Planning Services Sign Permit Review Form

Date of Submittal	Application Number	Applicant	Landowner
9/10/2025	SIGN2509-0005	Adam Kerian	USA % Army Corps of Engineers

Contact Person	Adam Kerian	Contact Number	608-407-9084
Sign Location	Intersection of NC 24-87 & Nursery Rd.	PIN Number	9593-15-5757.000

Sign Installed at Intersection of Hwy 24 & Nursery Road
* Sign will have arrows that point down Nursery Road.

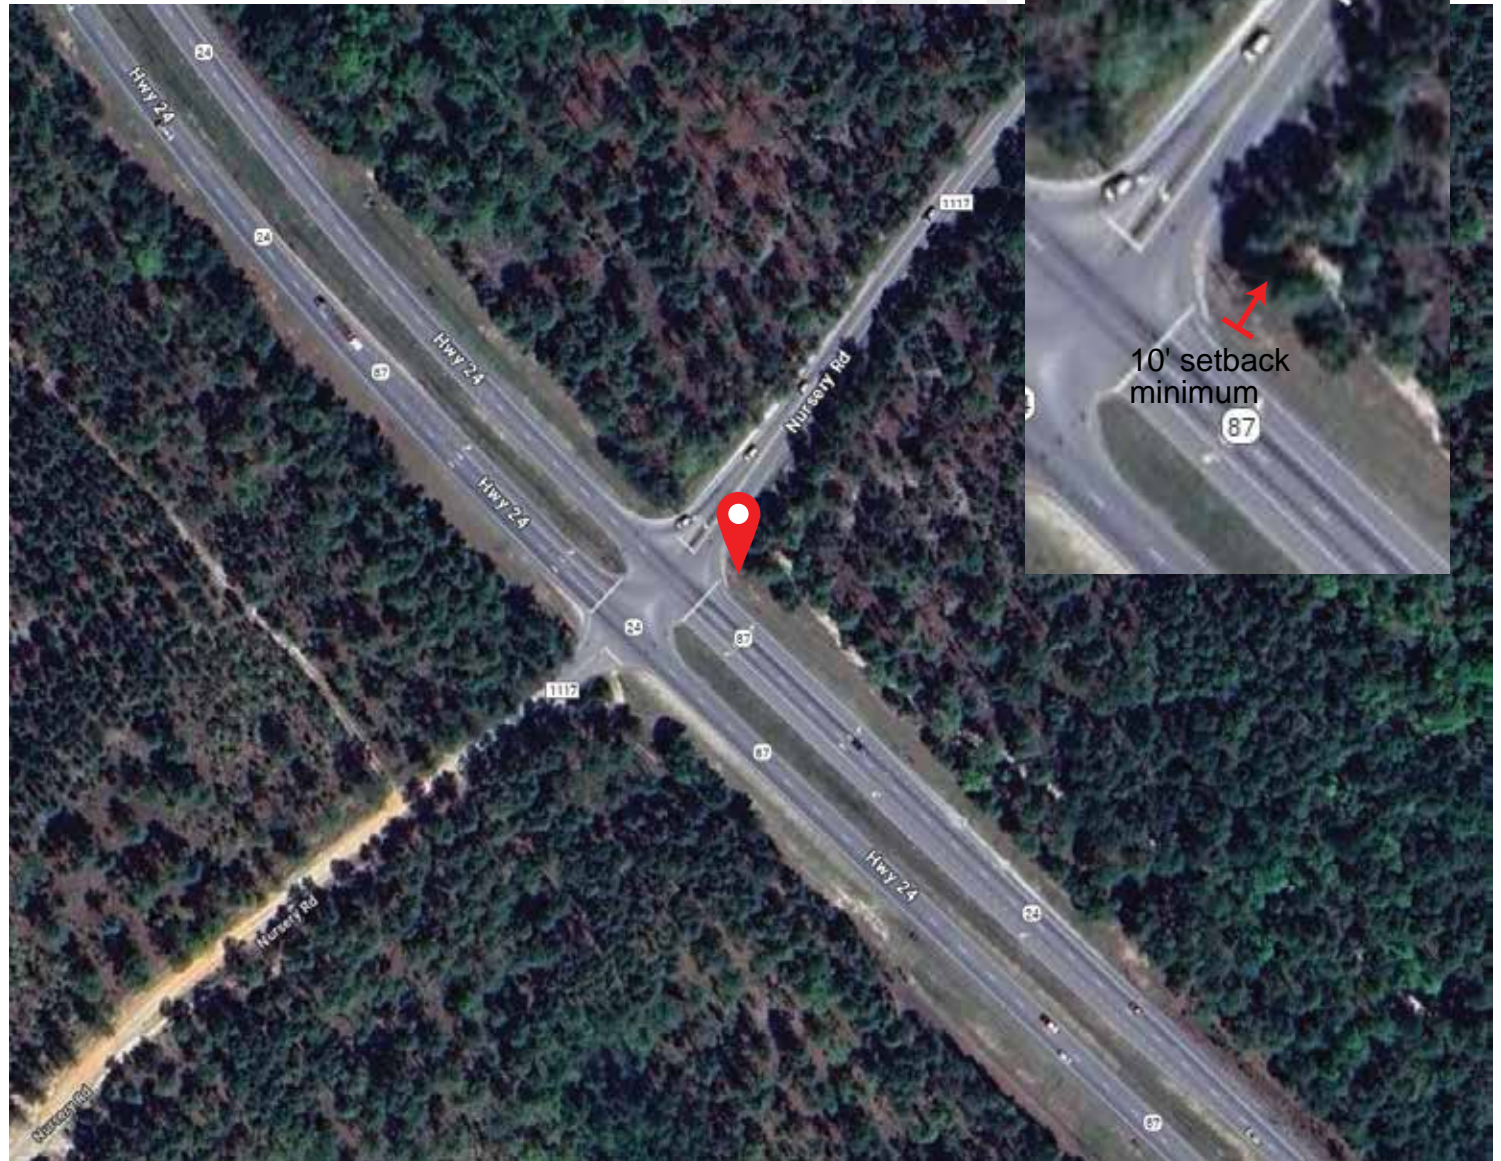
Comments	Sign maximum height measured from the ground must not exceed 6 feet. In cases where signs are placed at intersections, the minimum setback shall be 20 feet as measures from each right-of-way or property line in both directions.
----------	---
